Technical Note

Project title	Eastern Creek Energy from Waste Facility	Job number
		239880-03
cc	Chris Ritchie, DoPE Sally Munk, DoPE Henry Moore, NSW EPA Deanne Pitts, NSW EPA	File reference
Prepared by	Giles Prowse/Joyanne Manning Joyanne Manning	Date
		16 March 2017
Subject	EIS Review - Key Technical Queries

The Next Generation NSW Pty Ltd ('the Proponent') submitted an amended Environmental Impact Statement (EIS) in November 2016 for their proposed Energy from Waste Facility at Eastern Creek ('the proposed facility').

Arup have undertaken a review of the amended EIS ('the EIS'). The purpose of this review is to assess the adequacy of the EIS in light of the three Arup reviews previously undertaken of the application documentation provided by the Proponent. The previous reviews

**Figure 3 Average macroscopic composition of "floc waste TNG" (dry basis)**

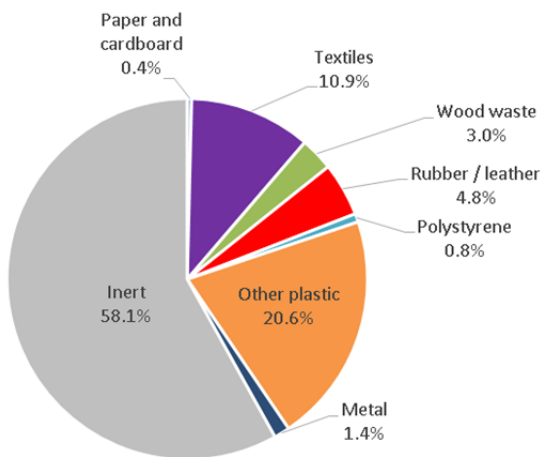
Appendix CC also includes a composition in figure 3 of shredder floc based on 17 samples, although no specific source for location, date, source, and the types of vehicle the floc is generated from is provided. This composition is different to the estimated composition in Appendix DD.6. A different Net Calorific Value (NCV) is also presented to the NCV in the EIS (Figure 24). 11.6MJ/kg is stated in Appendix CC and 12.59 MJ/kg is stated in the EIS.
